2382/APP/2023/2906

Broadwater Lake, Moorhall Road, Harefield

Proposal: Redevelopment of the site to create the Hillingdon Watersports Facility and Activity Centre including demolition of existing Broadwater Lake Sailing Club (BSC) clubhouse at the north of the lake and erection of a building including changing facilities, meeting rooms, storage, Workshop and seasonal worker accommodation (sui generis), activity shelters; installation of pontoons and slipways; boat shed; equipment storage huts; boat parking and racking areas; camping area; outdoor activity areas; ecological enhancement throughout the site; new pedestrian routes through the peninsula; landscaping including new woodland, dense vegetation screens and boundary treatment; access road; localised dredging and land reclamation; relocation of existing sailing area and creation of floating reedbeds within the lake; coach drop off and turning area; vehicle parking; cycle parking; and associated works. (Re-consultation following submission of amended plans and documents)

The Herts and Middlesex Wildlife Trust strongly **objects** to the proposed development, as amended. Our reasons for objecting are set out fully below.

Figure 9: Existing and Proposed Sailing Areas

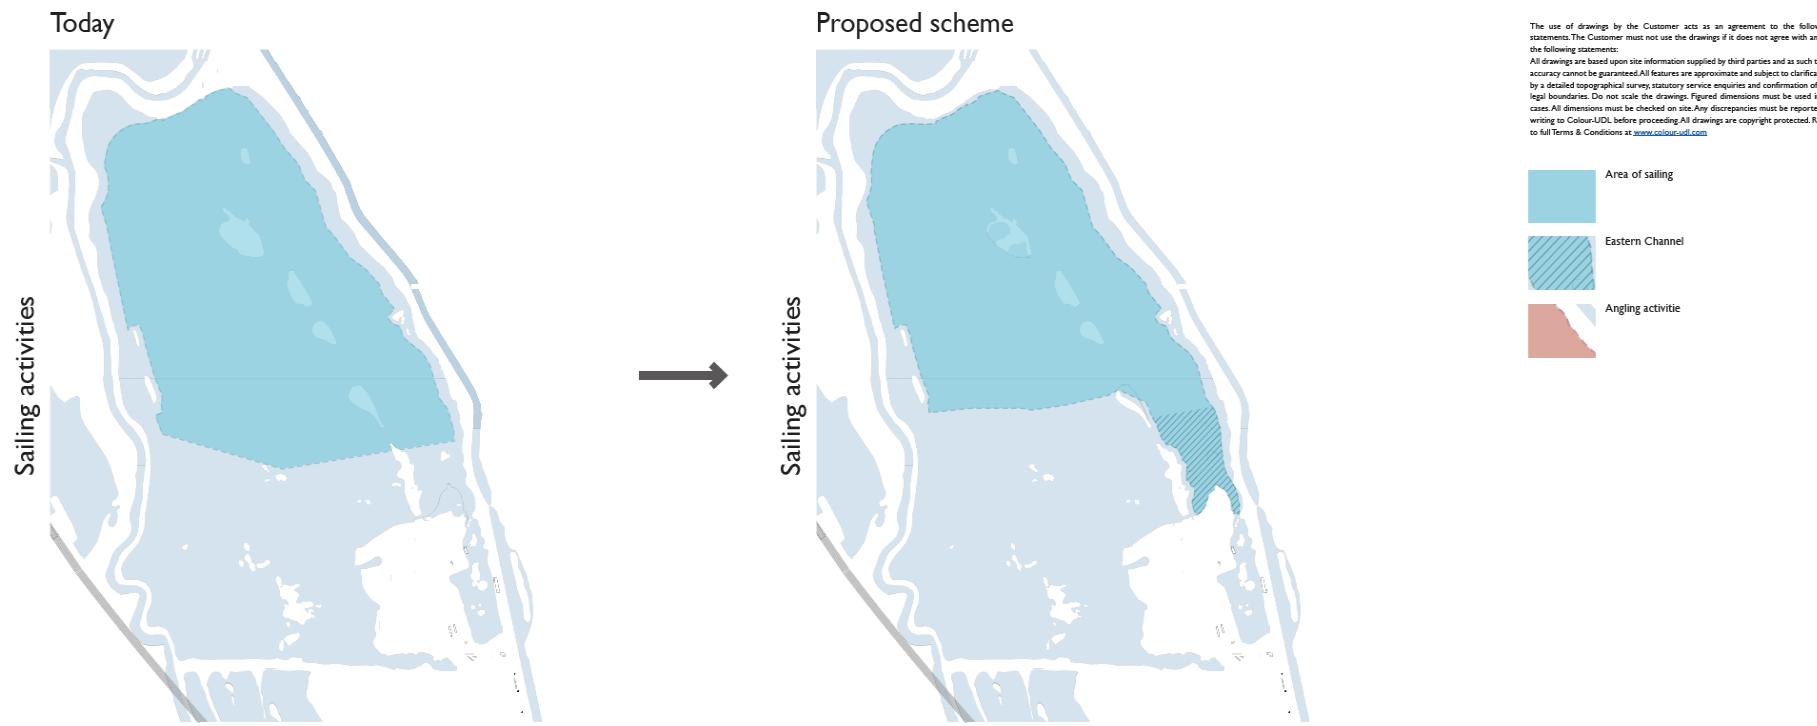
- Works within the main lake, including islands, are timed for September (ES Table 7.17), which is a critical period for moulting birds.
- The Eastern channel, where there is currently limited sailing and angling, is an important part of the lake for feeding ducks but is sacrificed to intensive watersports uses.

- The screen of willow planting in submerged planters, which separates the refuge from the sailing area, will be difficult to deliver and is likely to fail.

Figure 2.1: Site Masterplan Layouts

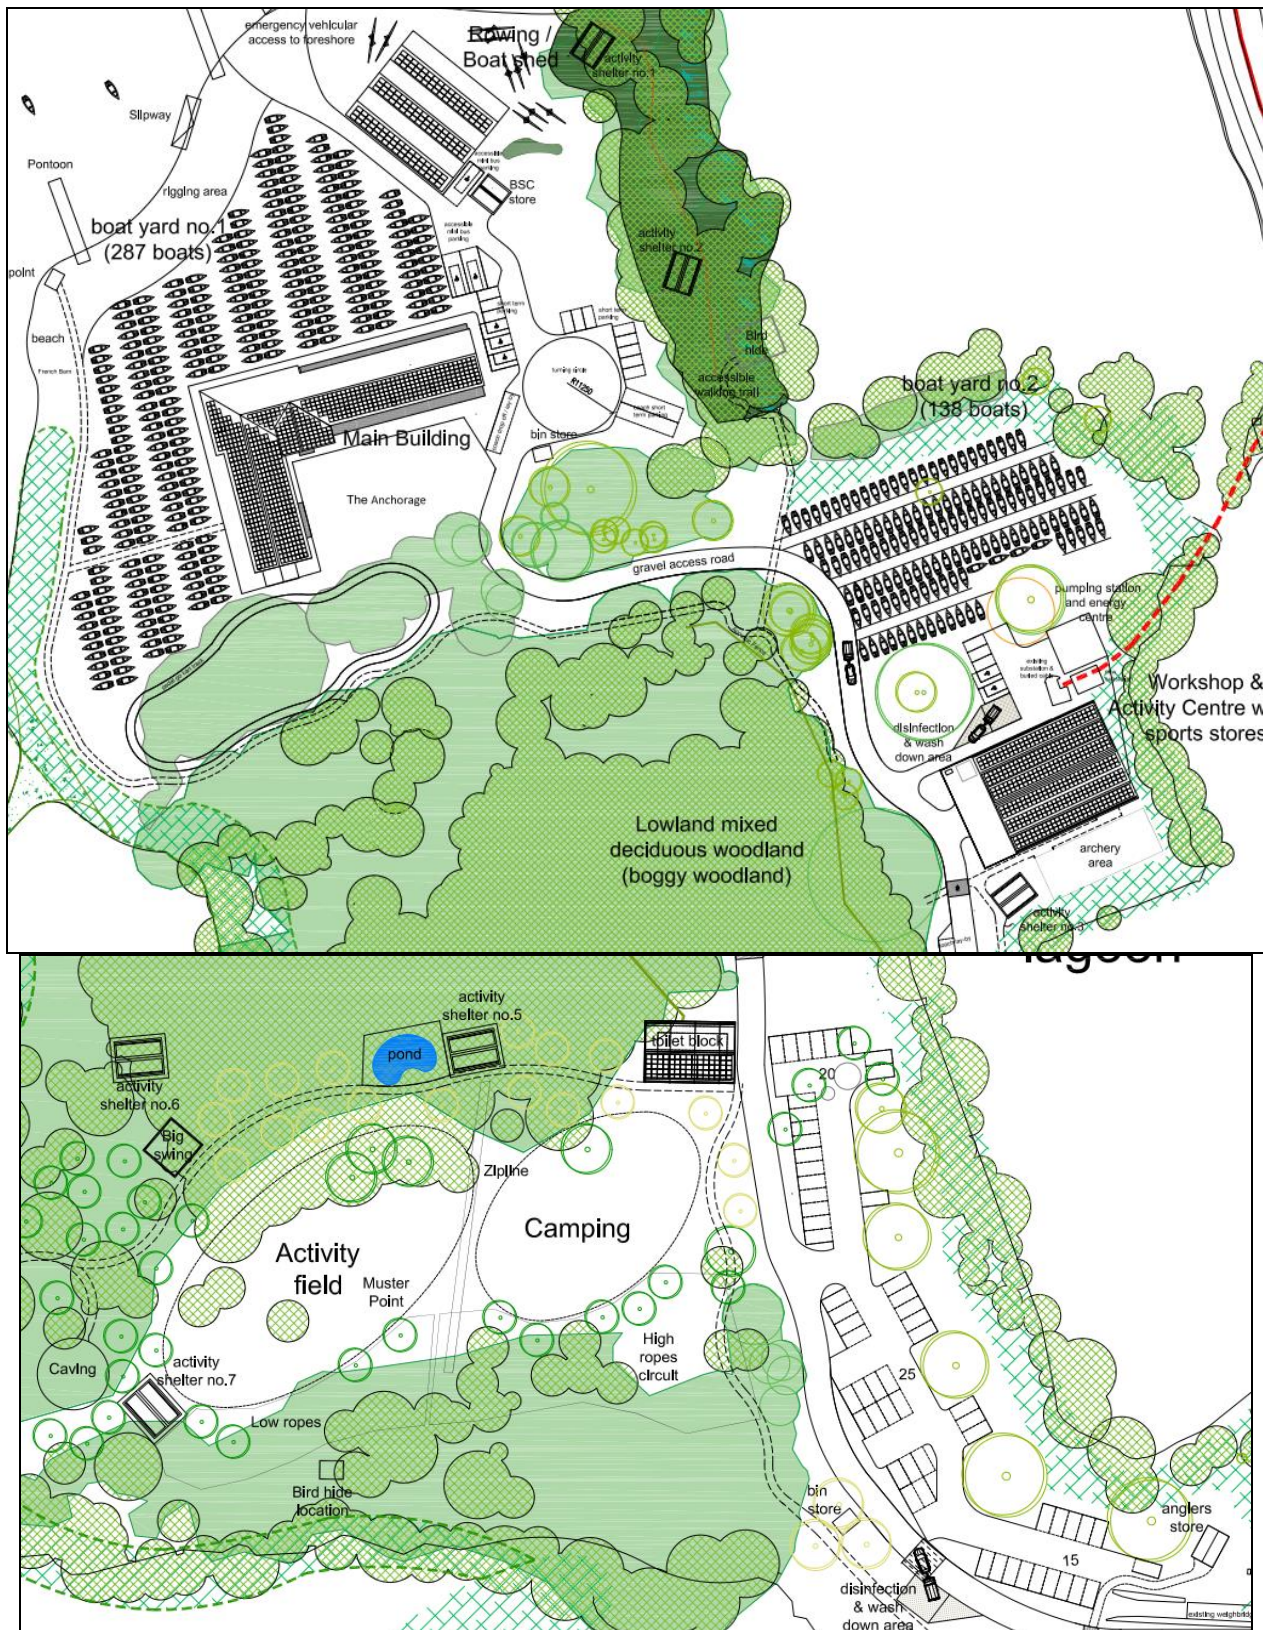
We are seeking clarity about the range of land-based uses that is now proposed. The Environmental Statement (ES) Non-Technical Summary states (p15) that archery, a big swing, high and low ropes, zip wire and pedal carting are no longer included, but the description of development (p17) includes zip line and big swing, which are shown on plans.
